Planning Act 2008 and The Infrastructure Planning (Examination Procedure) Rules 2010

Application by Highways England ("the Applicant") for an Order granting Development Consent for the A303 Sparkford to Ilchester Dualling.

REQUEST FOR COMMENTS FROM ALL INTERESTED PARTIES

Application by Highways England ("the Applicant") for an Order granting Development Consent for the A303 Sparkford to Ilchester Dualling.

**WORK NO 5
(PODIMORE TURNING HEAD)**

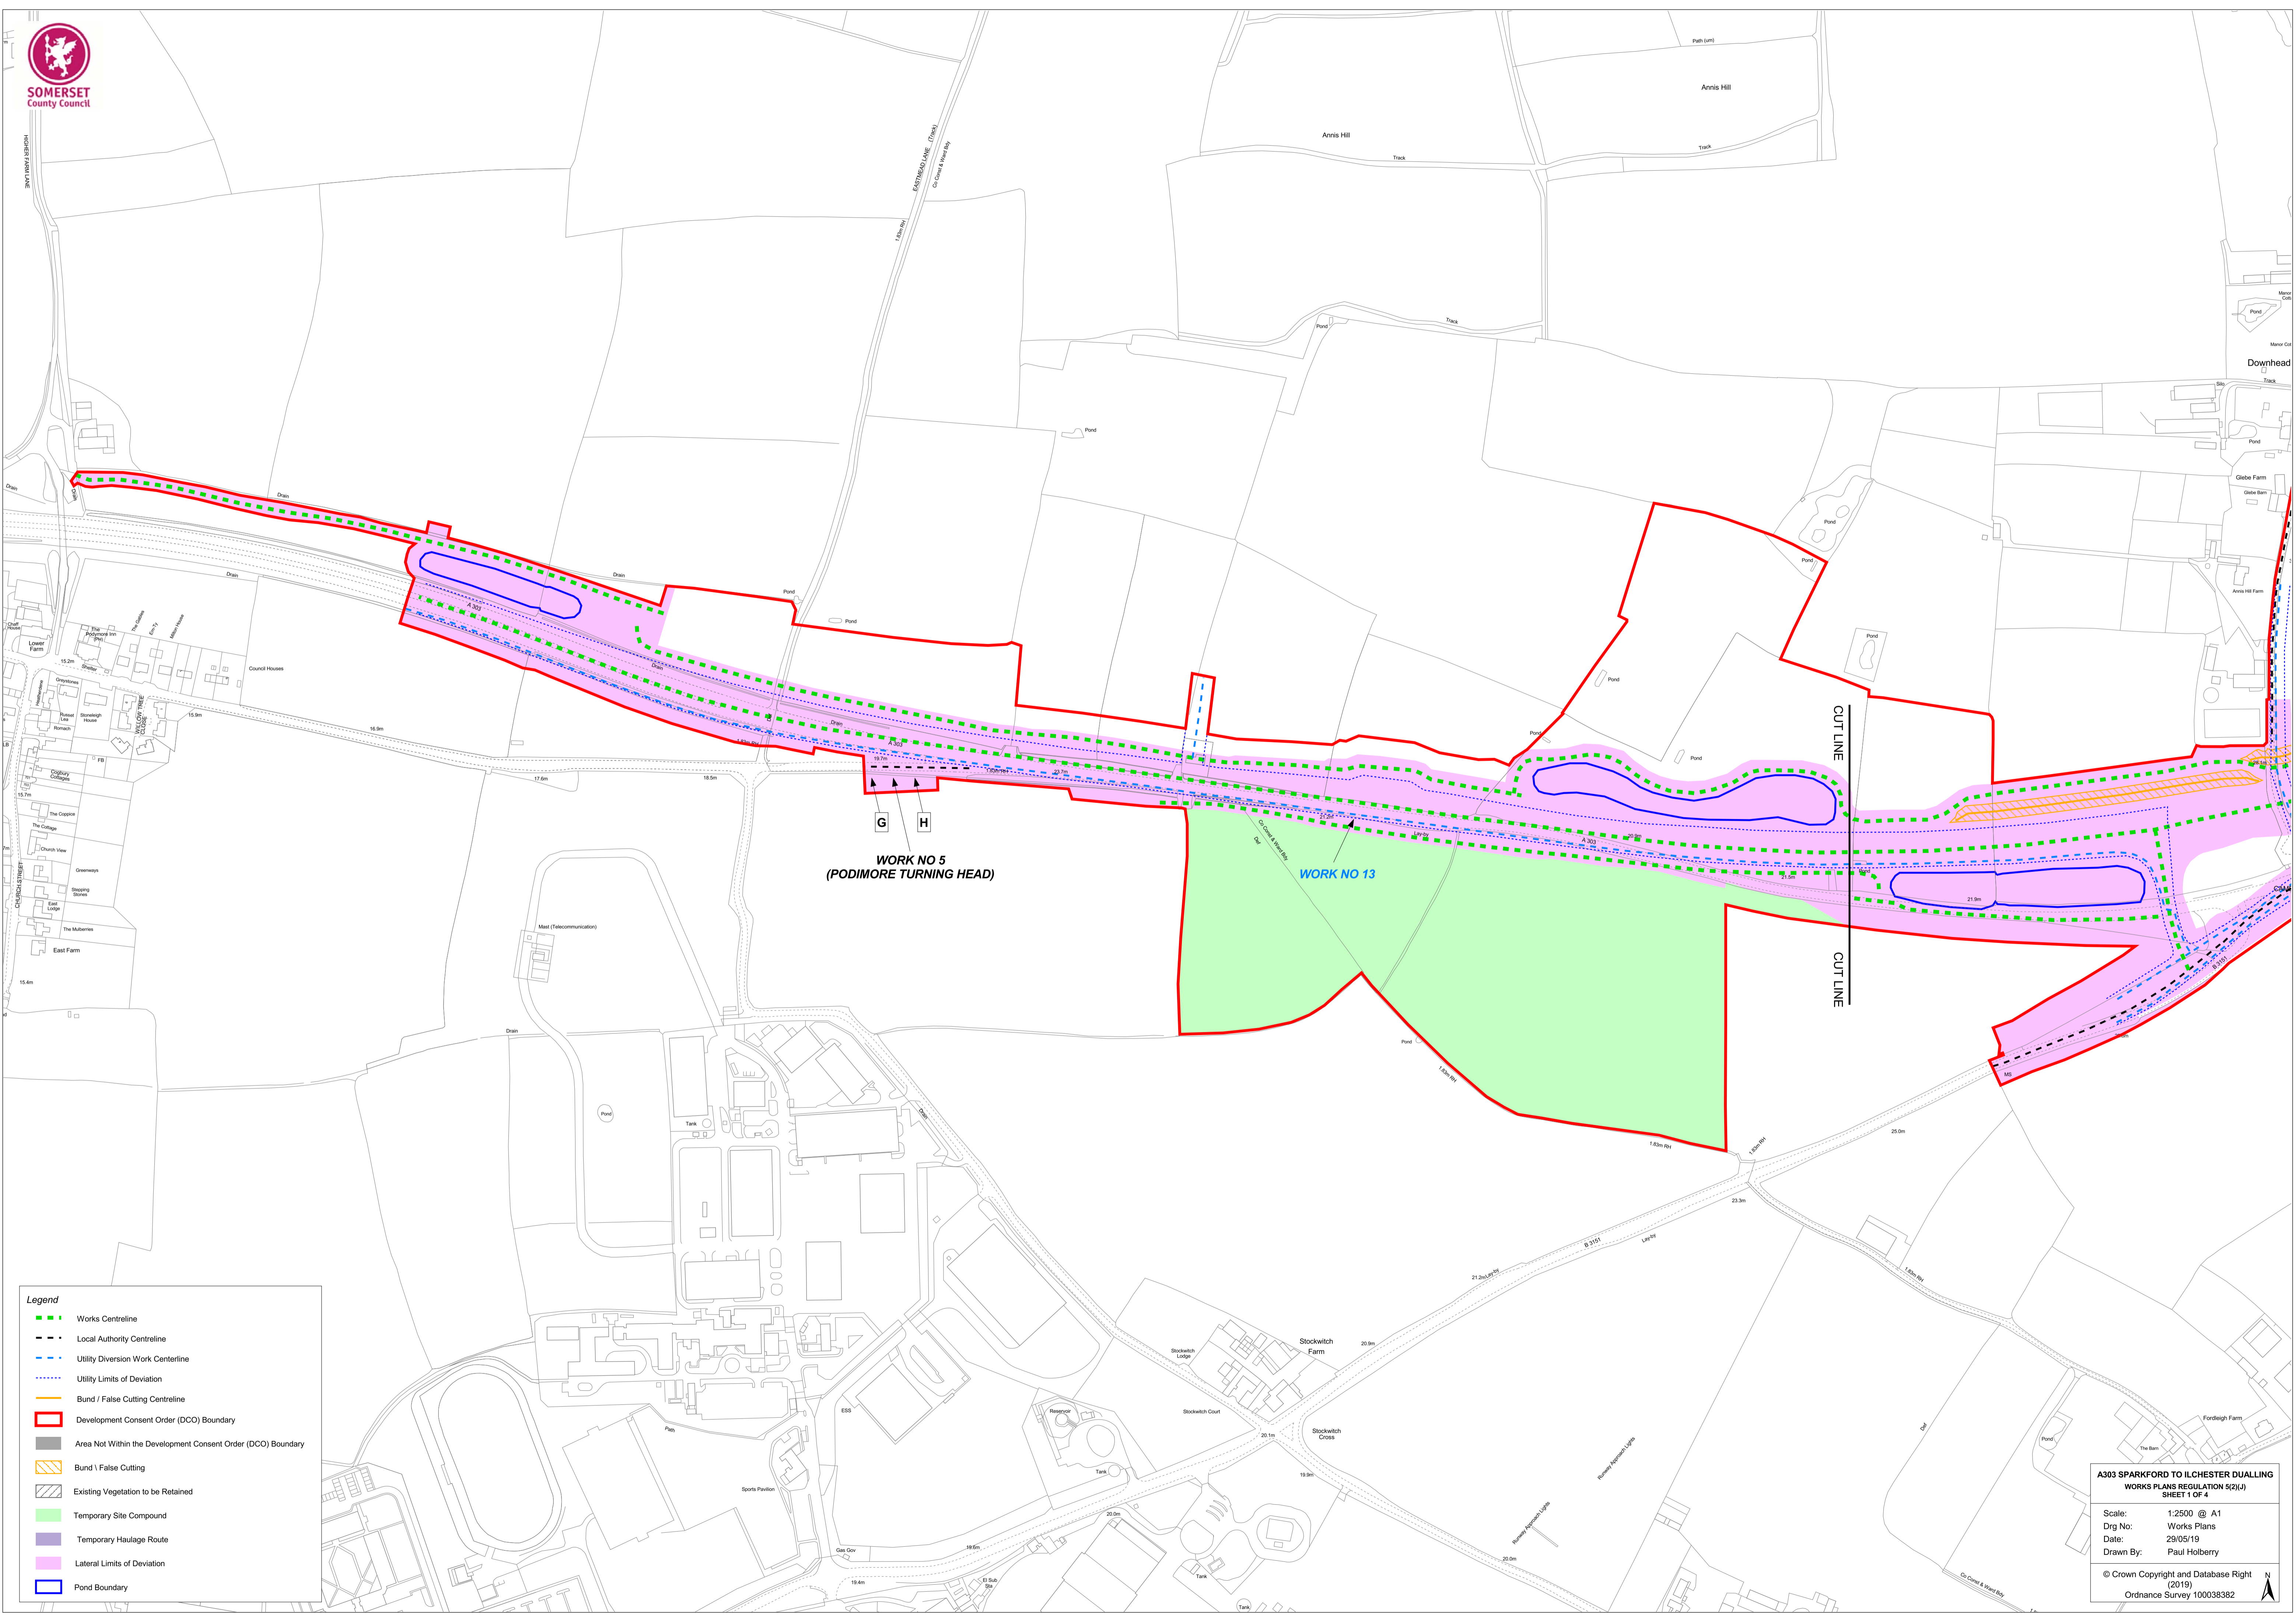
Within our submission we noted that the DCO boundary did not extend beyond the proposed turning head to the West of the existing Podimore slip, yet such a facility would not in practice be possible to use given the existence of a Traffic Regulation Order (TRO) preventing the flow of traffic from the junction of Stockwitch Lane and Podimore Road towards the existing A303. Indeed, the associated TRO would prevent access by even pedal cyclists and equestrians, not just motorised vehicles. In our response, we highlighted that there is a significant risk that such a cul-de-sac may be used as an unauthorised traveller encampment and, at the Issue Specific Hearing on Traffic and Transport on 26 February 2019, we sought that the highway between the existing A303 and the junction of Stockwitch Lane and Podimore Road should be stopped up and the land turned to green field. All

highway rights should also be removed, and the associated Traffic Regulation Orders would also need to be revoked. It was understood at the time that HE was developing outline design details in relation to the Podimore slip that should help to address the County Council's concerns on this matter, and that it would be willing to enter into a S.278 agreement to secure the necessary works outside the development boundary to be delivered by HE at its own expense.

As we believe HE and SCC are in agreement that physical works are required and we believe these can be delivered within the current limits of the public highway, this could be worded by way of a Grampian type requirement providing for agreement of a scheme of works to be delivered by HE and at their own expense.
